Title: Figure 3.1.1 Field Numbering Plan
Green Hill A & A.2

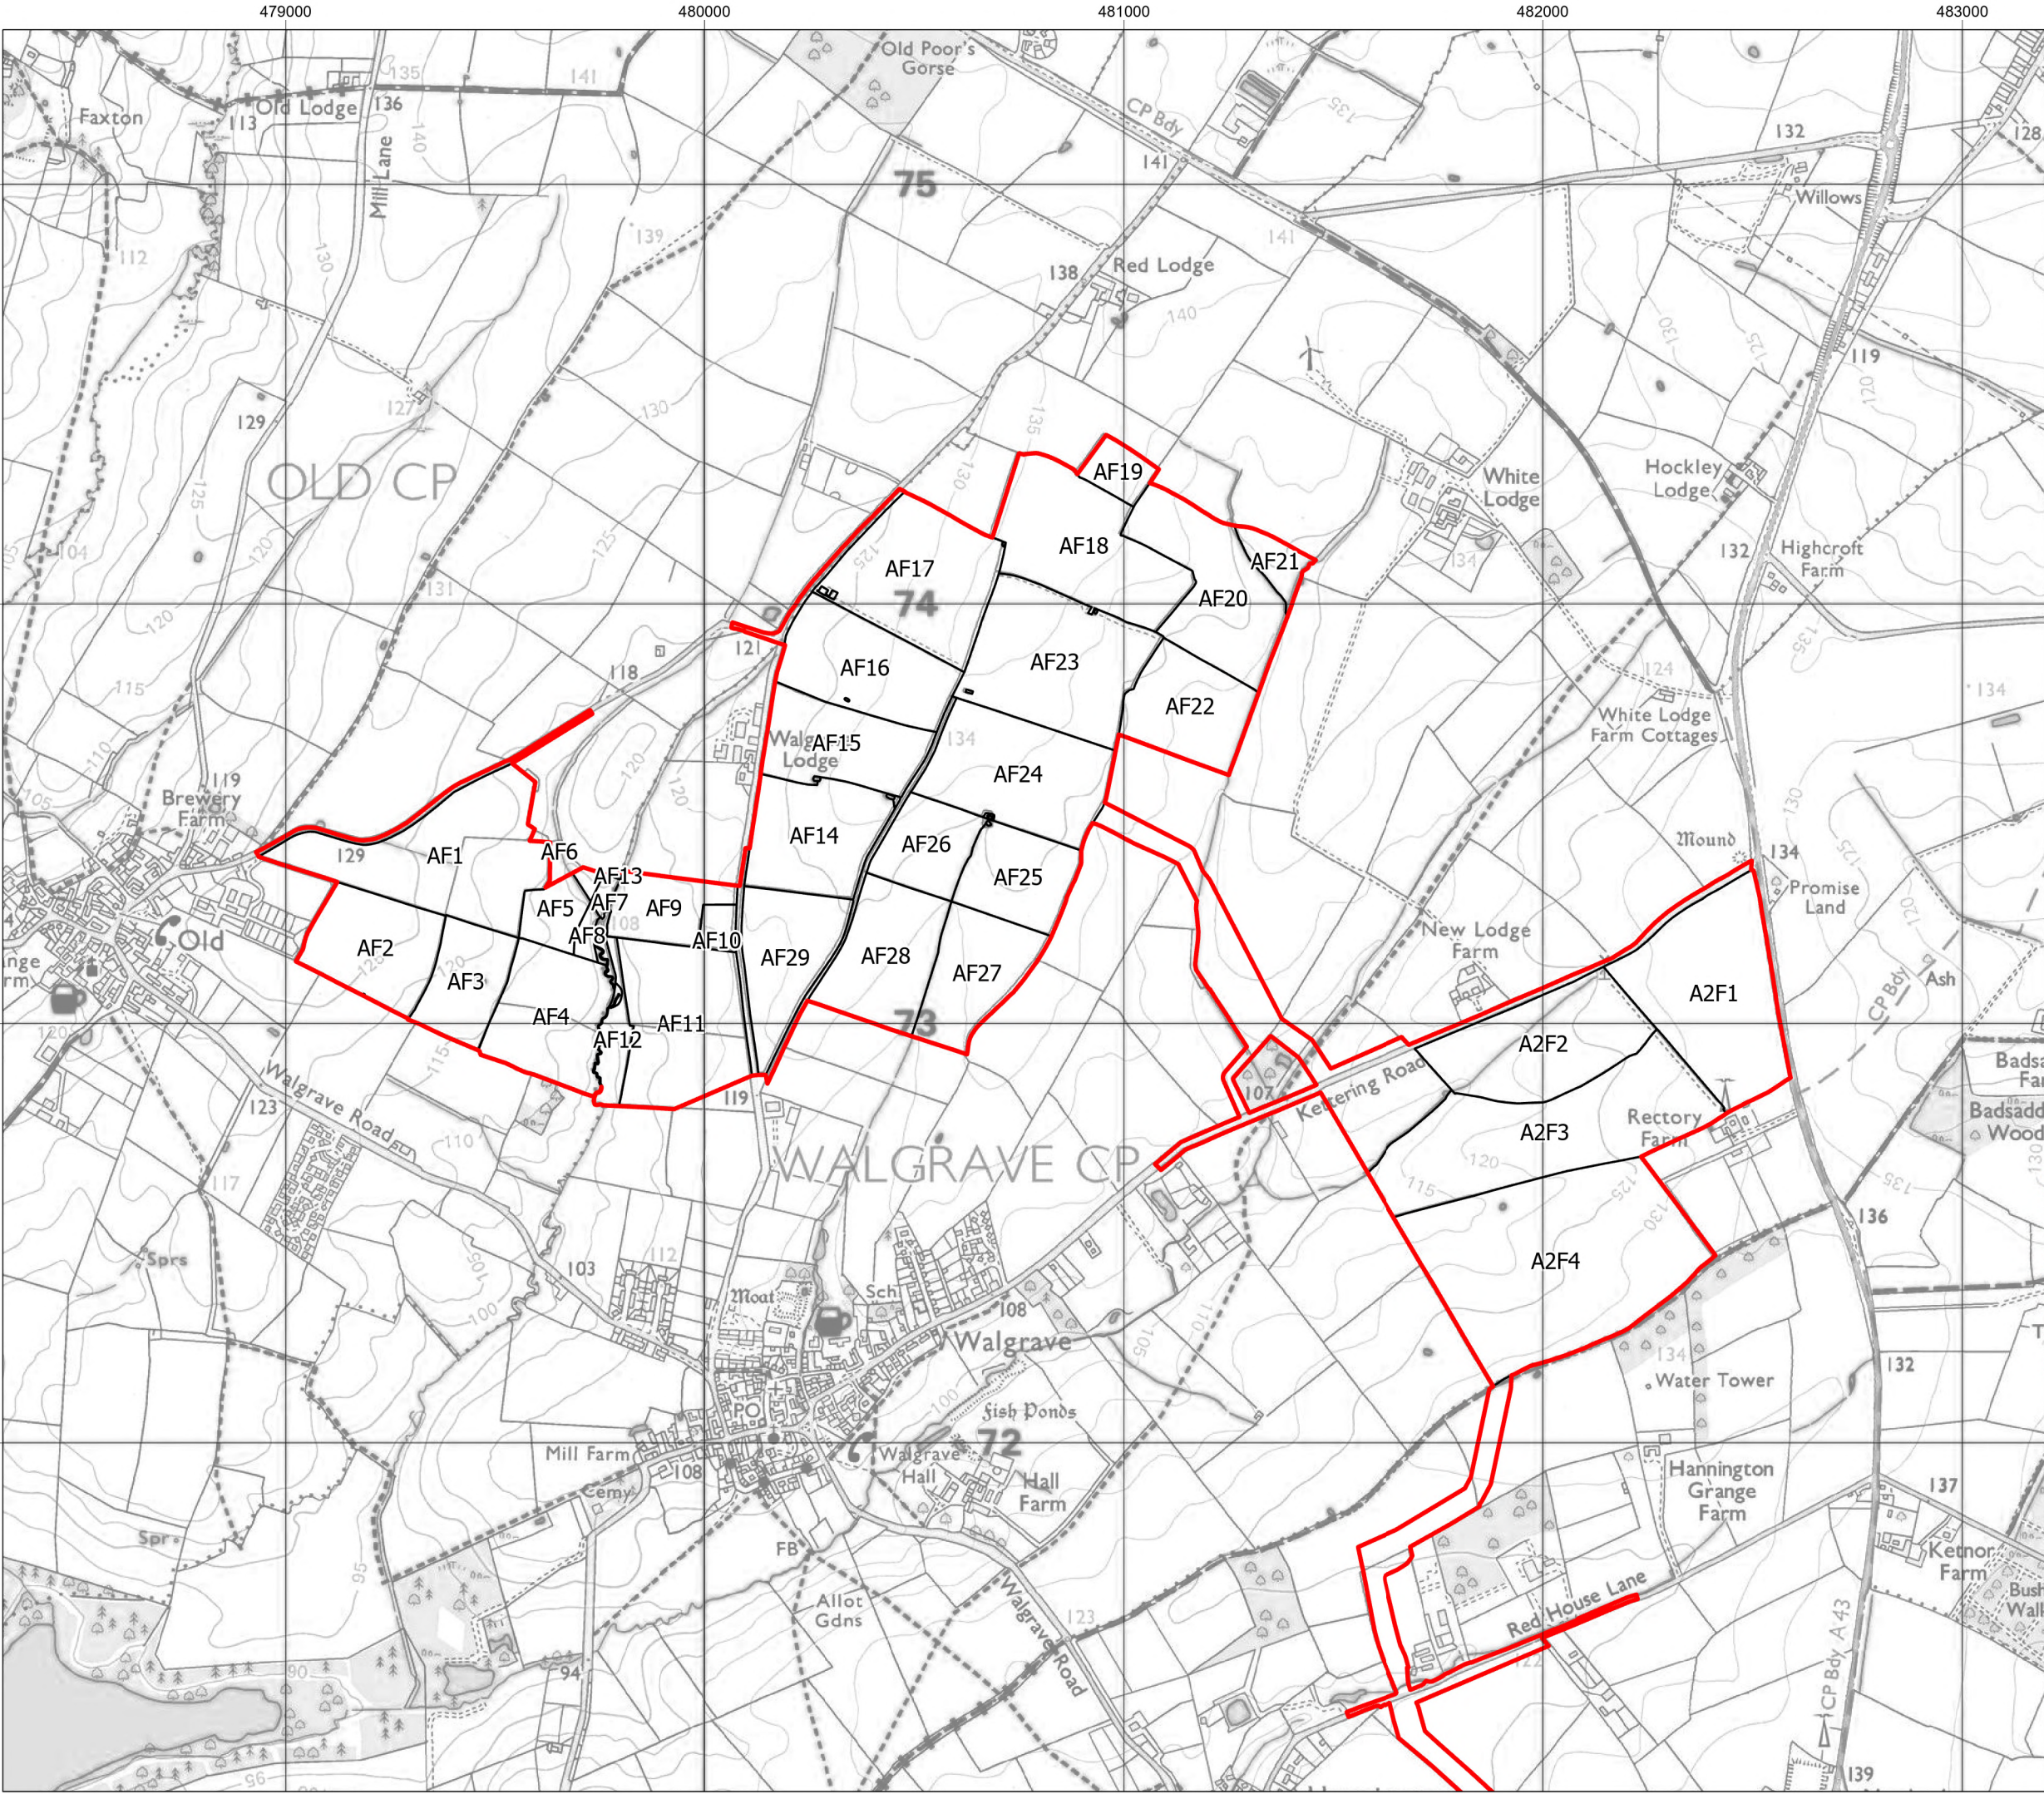
Site A

Remove or reduce the solar arrays next to the road

AF 14, 15, 16, 17 and AF 29 - I appreciate that AF 29 has now been removed but we need to go much further.

Site A2

Remove AF1 and AF2

Title: Figure 3.1.3 Field Numbering Plan
Green Hill C, D & E

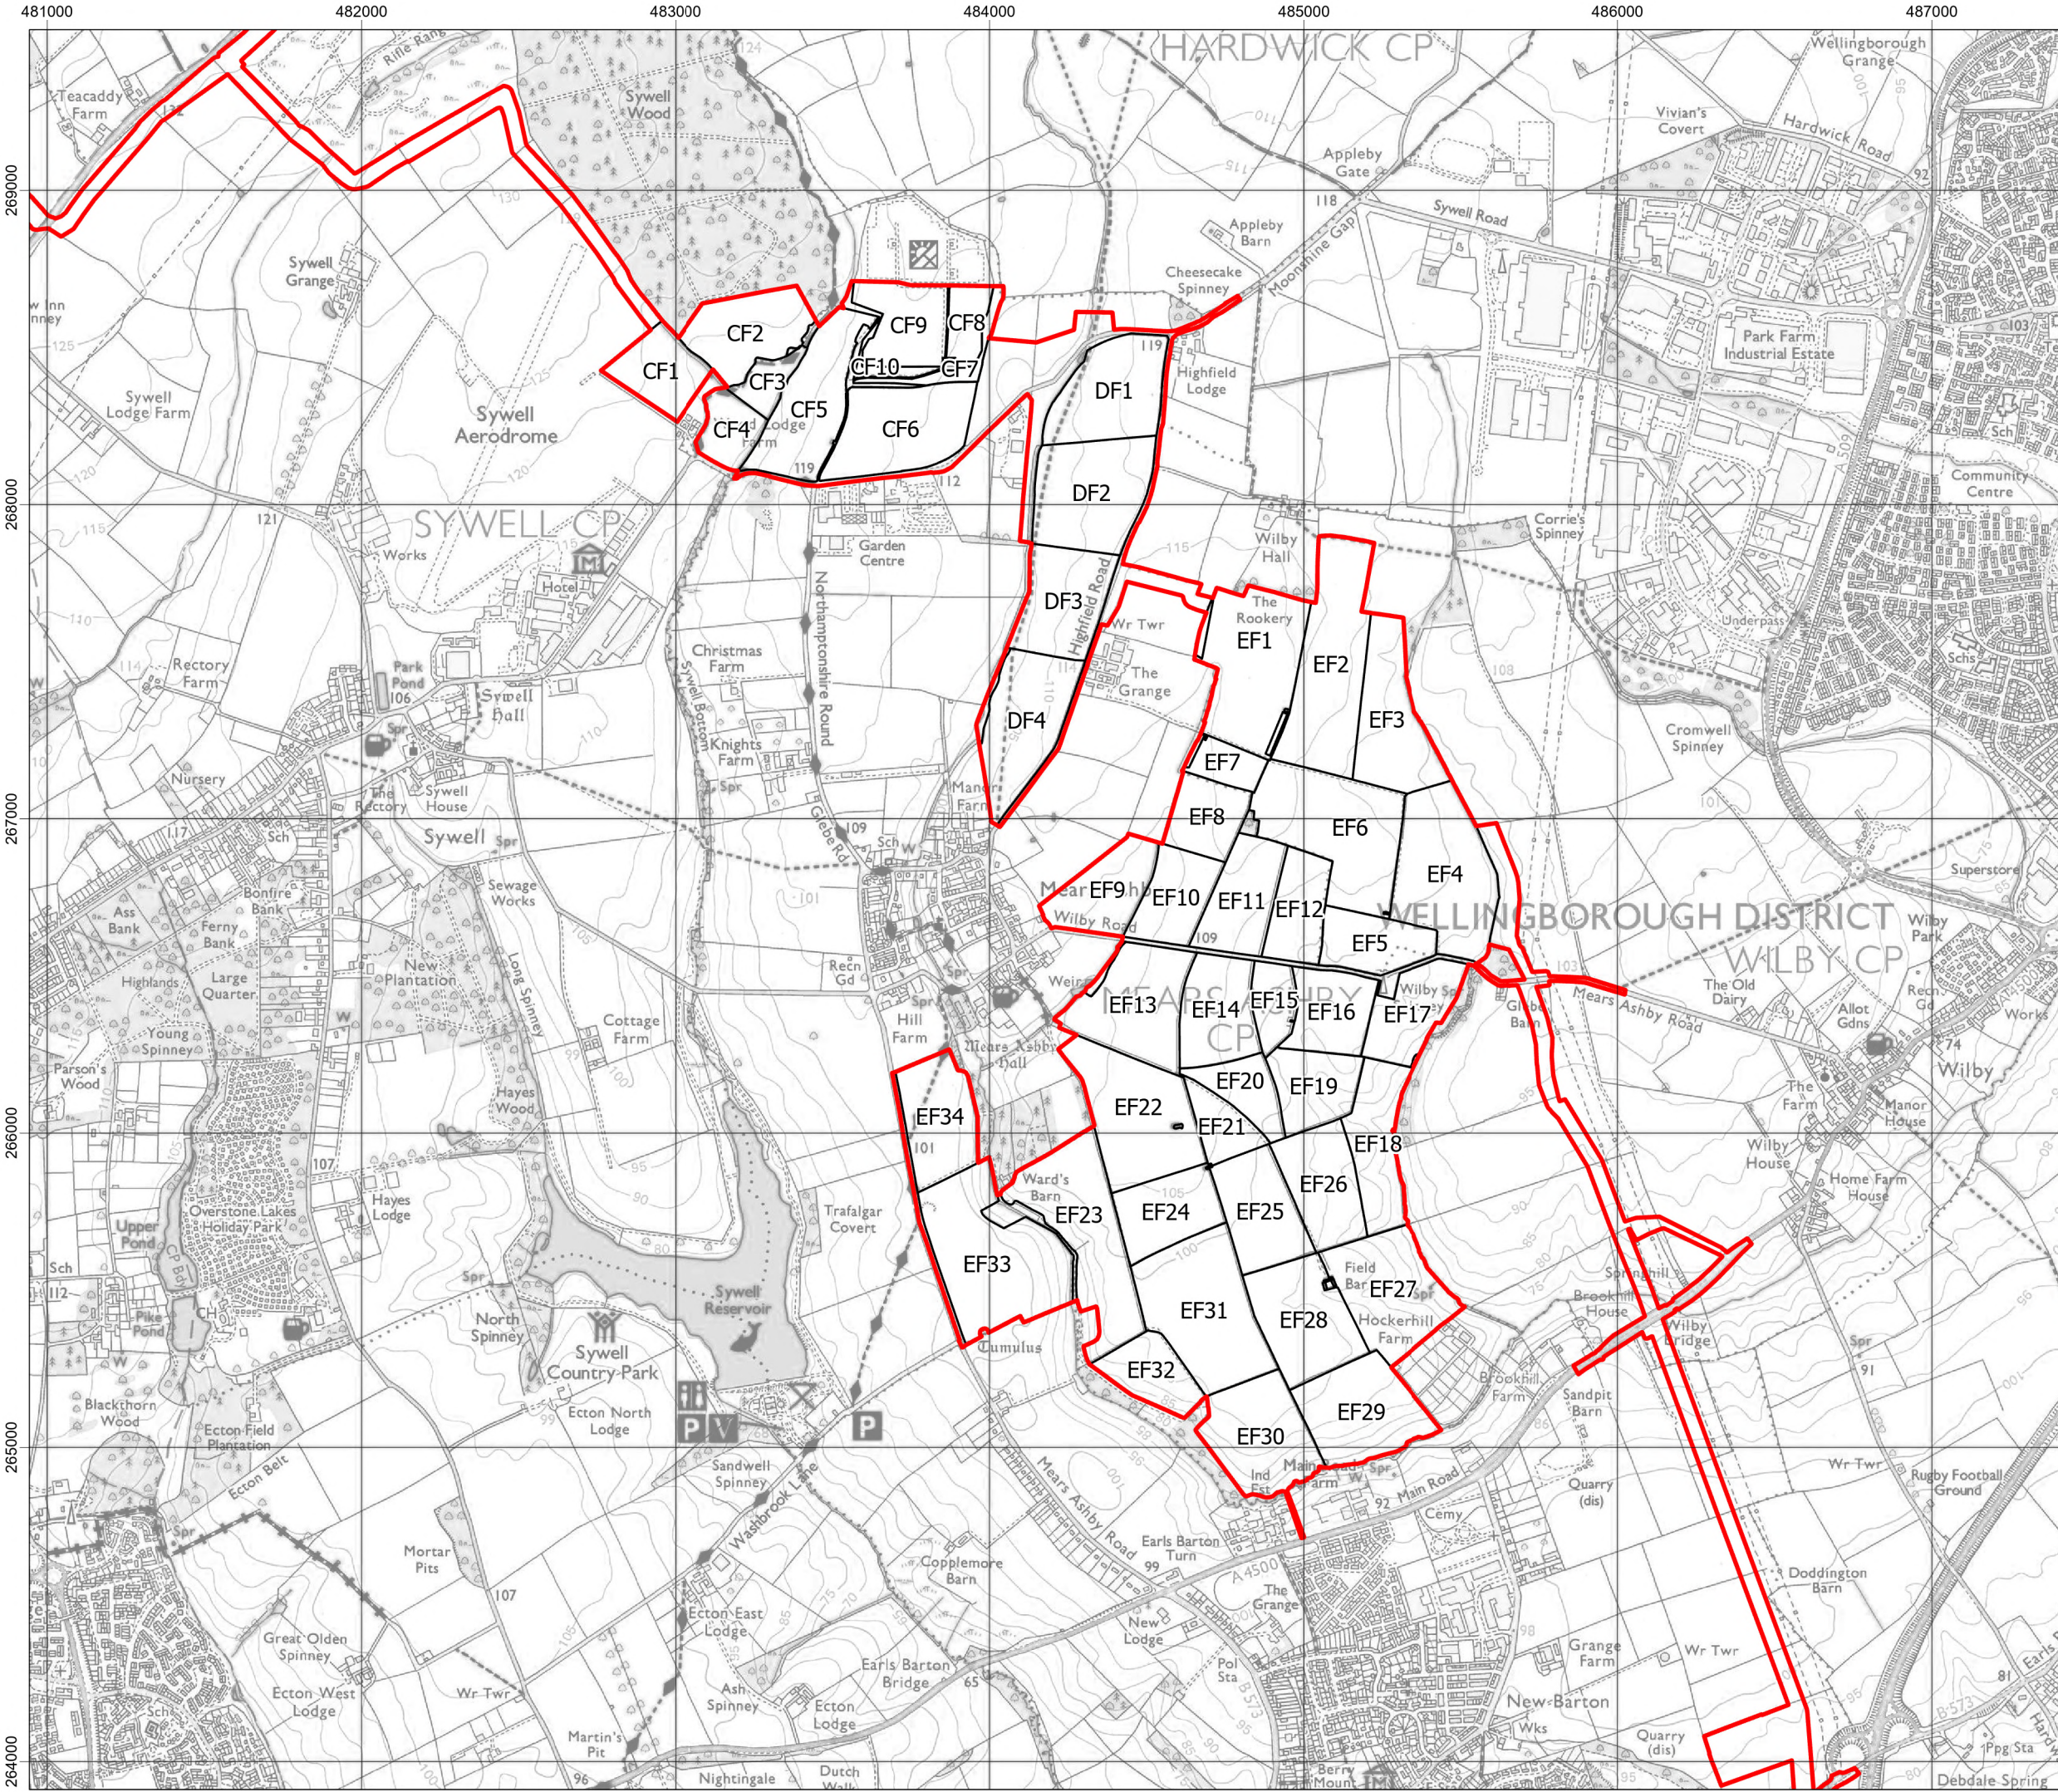
Site C

Remove CF1 and CF6 as they are too close to buildings

CF5 Push the panels back away from the road

Site D

Remove DF1,2 and 3 as they are all too close to farms and business

Site E

Remove EF33 - Too close to the road

EF 22 - Push back panels to start in line with field EF23

EF 10,11,12 and 5 - Push back away from the road so less obtrusive

EF 13,14,15 and 16 - Push panel back away from the road to make a clearer corridor

Title: Figure 3.1.4 Field Numbering Plan
Green Hill F & BESS

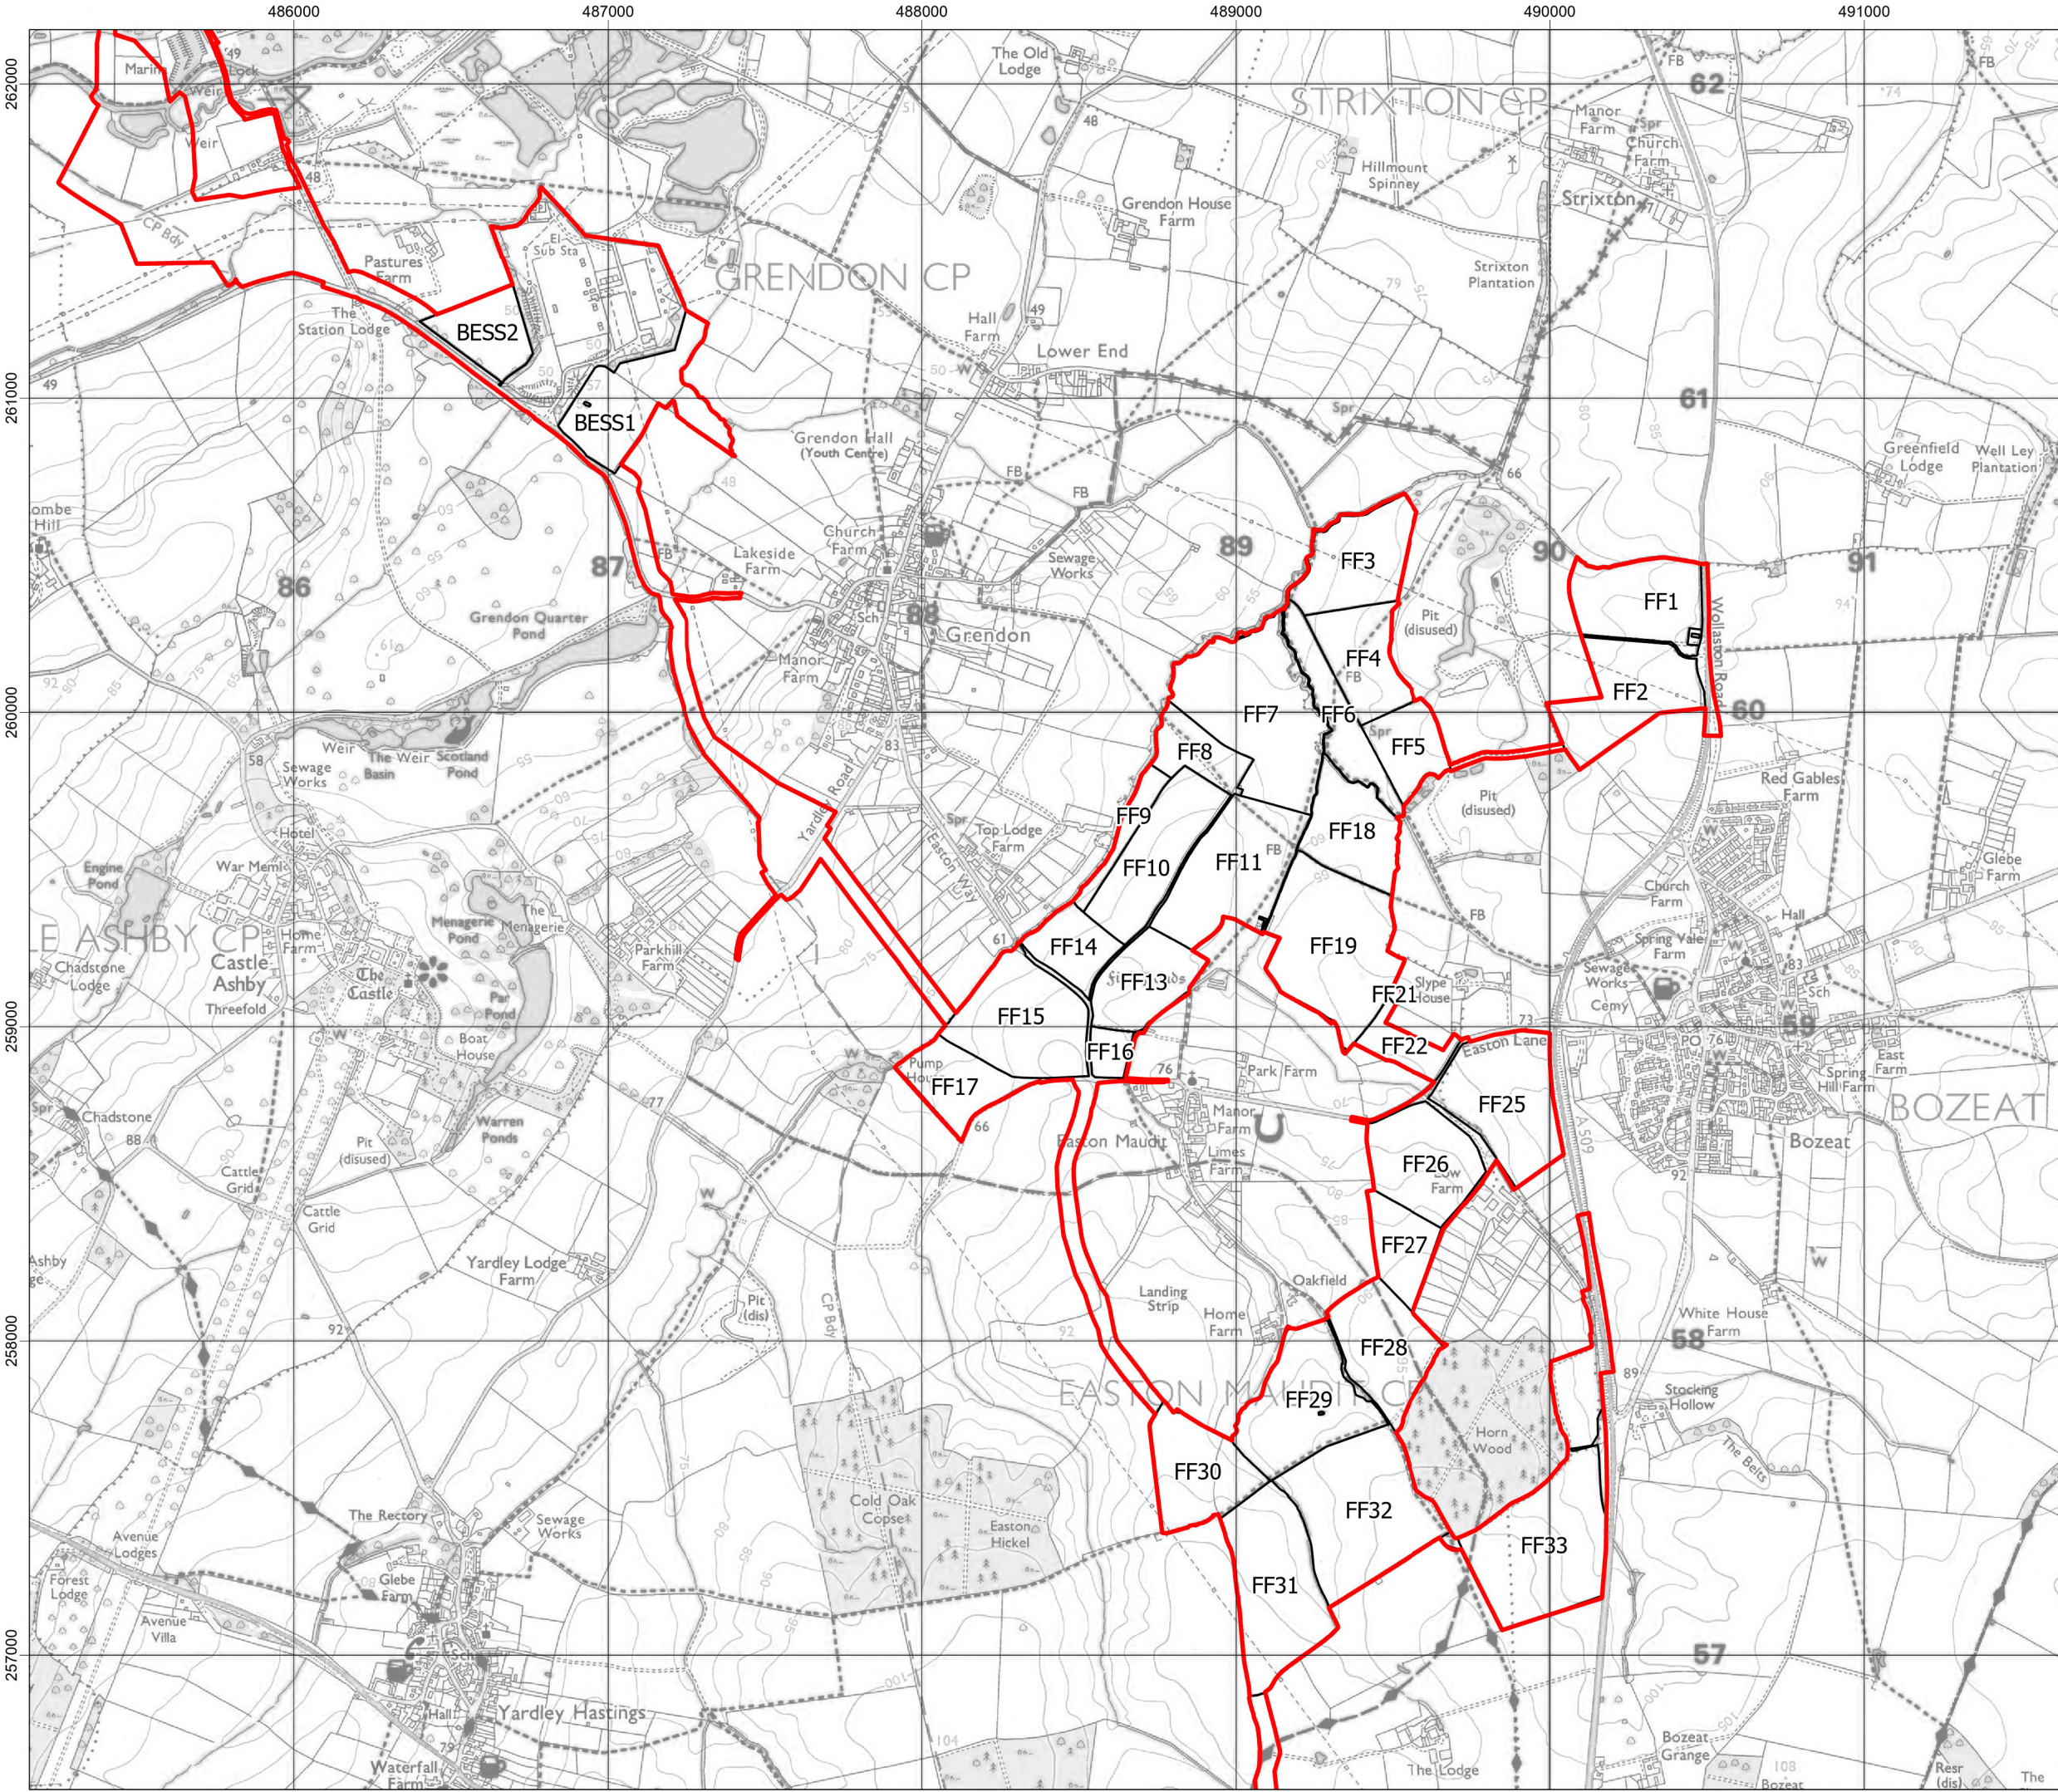
Site F

FF10 Push panels back from the PROW

FF11 reduce the panels from the NE and SE side of the field around the PROW

FF18 and FF19 - Push the panels back further to make a wider PROW
